**DEXUS QUARRYWEST PROJECT (SSD 6801) – SECTION 96 MODIFICATION (MOD 3) –  
RESPONSE TO SUBMISSIONS**

DEXUS Quarry WEST Subtrust (DEXUS) is proposing to modify the development consent for the QuarryWEST Project within the Greystanes Southern Employment Lands. The proposed modification involves relatively minor changes to the layout of Precinct B of the estate, and is described in the Statement of Environmental Effects (SEE) for the proposal dated 17 February 2017.

**Re: SSD 6801 Mod 3 QuarryWEST Project, DEXUS Estate, Warehouse and Distribution Centre,  
Reconciliation Road, Pemulwuy, section 96 modification application**

Figure 5: Warehouse B2 Eastern Elevation – As Proposed

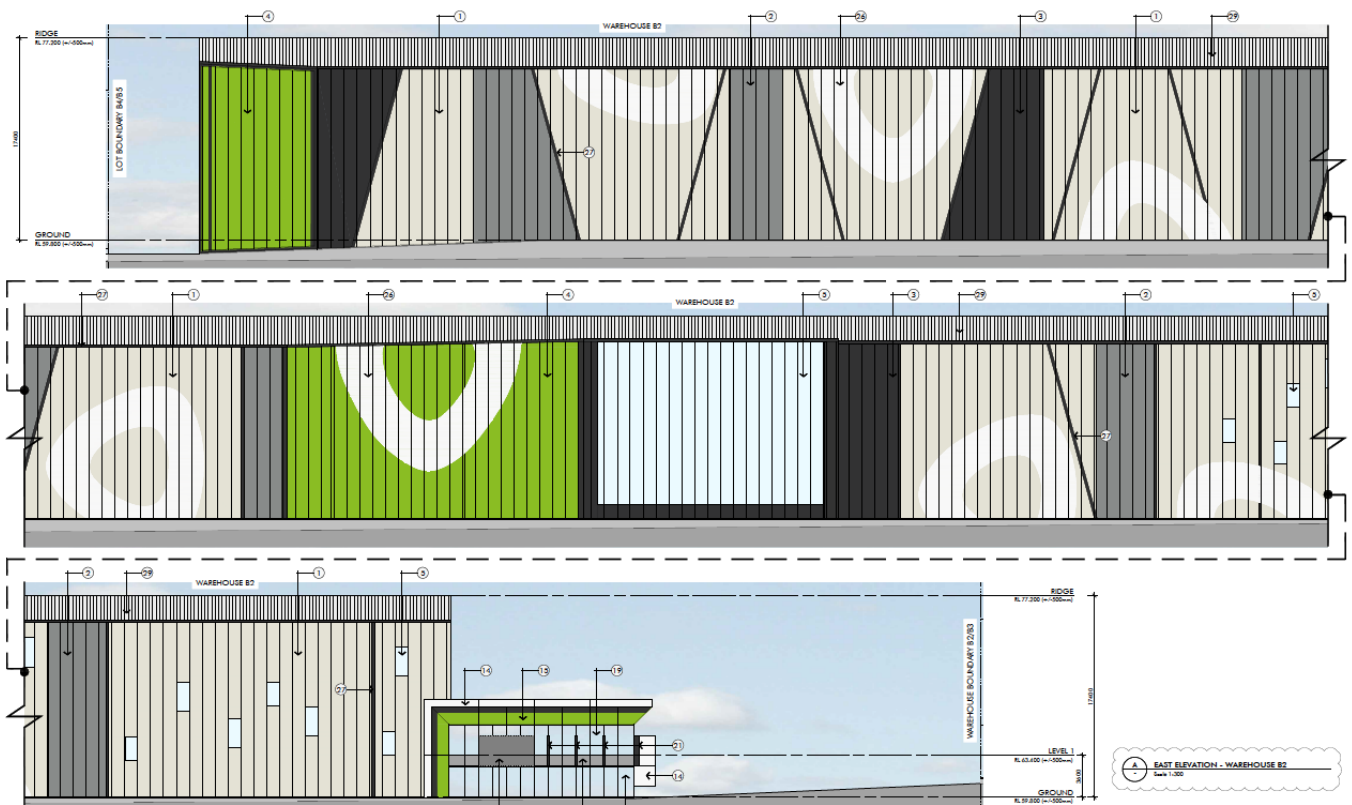
RMS and Cumberland Council did not raise any objections or issues associated with the proposed modification. Blacktown City Council did not raise any objections, although it requested that DEXUS provides 'details of the necessity for the increased height, for example is this essential to accommodate a racking system', in order to demonstrate the need for the increased height.

- the high clearance/high density materials handling equipment (MHE) system that is proposed to be installed within the building. The MHE system has a height of 12.7 metres, and to meet fire regulations a ceiling with sprinkler protection is required to be suspended from the structure at a height of 13.7 metres; and
- an increased roof pitch (2.5 degrees) to address the risk associated with increased hail loads as experienced in Sydney in recent years (which have lead to some notable warehouse collapses).

The building is designed to accommodate this MHE system which will have product stored up to a maximum height of approximately 12.7 meters across the entire facility. In order to comply with fire regulations a ceiling with sprinkler protection is required to be suspended from the structure at 13.7 metres in order to provide adequate fire protection to the building.

It should be noted that the structural design has not only had regard for the above but also has considered recent weather events in western Sydney with the roof pitch increased to 2.5 degree (from a eaves height of approximately 14.9 metres) in order to offset the risk of potential hail loads that have been recently experienced. Should the roof pitch be reduced to approximately 1.0 degrees as adopted on some warehouse projects the ridge height would reduce to circa 15.5 metres, this design would not be covered by a roof sheet warranty or be considered safe.

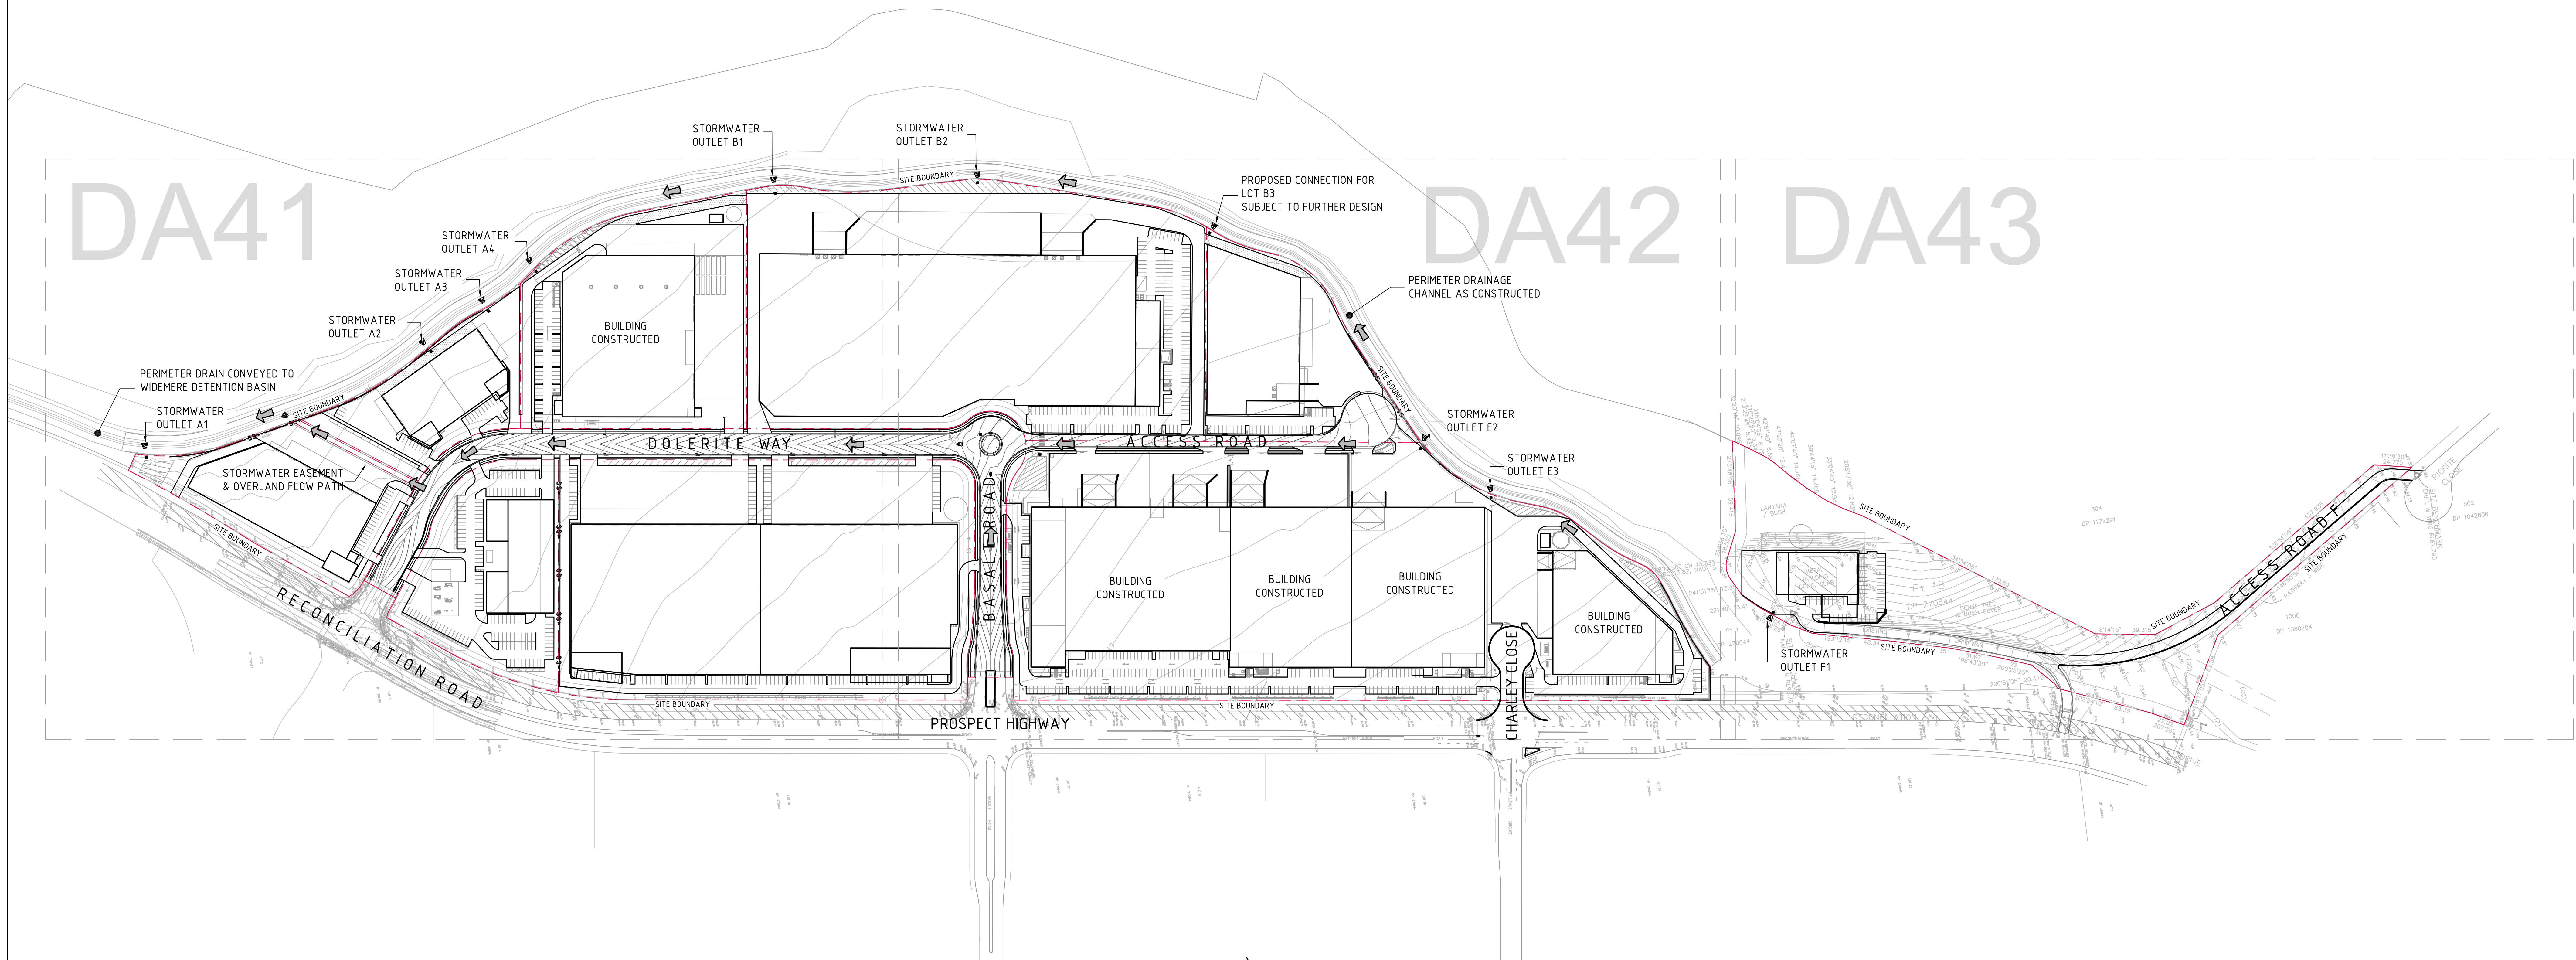
- updated estate elevations and sections showing the proposed modifications; and
- revised versions of stormwater plans (DA41 and DA 46) to correct revision and date details.

The updated estate elevations and sections are attached as **Attachment B**, and the updated stormwater plans are attached as **Attachment C**. It is noted that all of the civil/stormwater plans required updating to correct the revision details, and as such the complete set of civil plans (and review report) is provided in Appendix C.
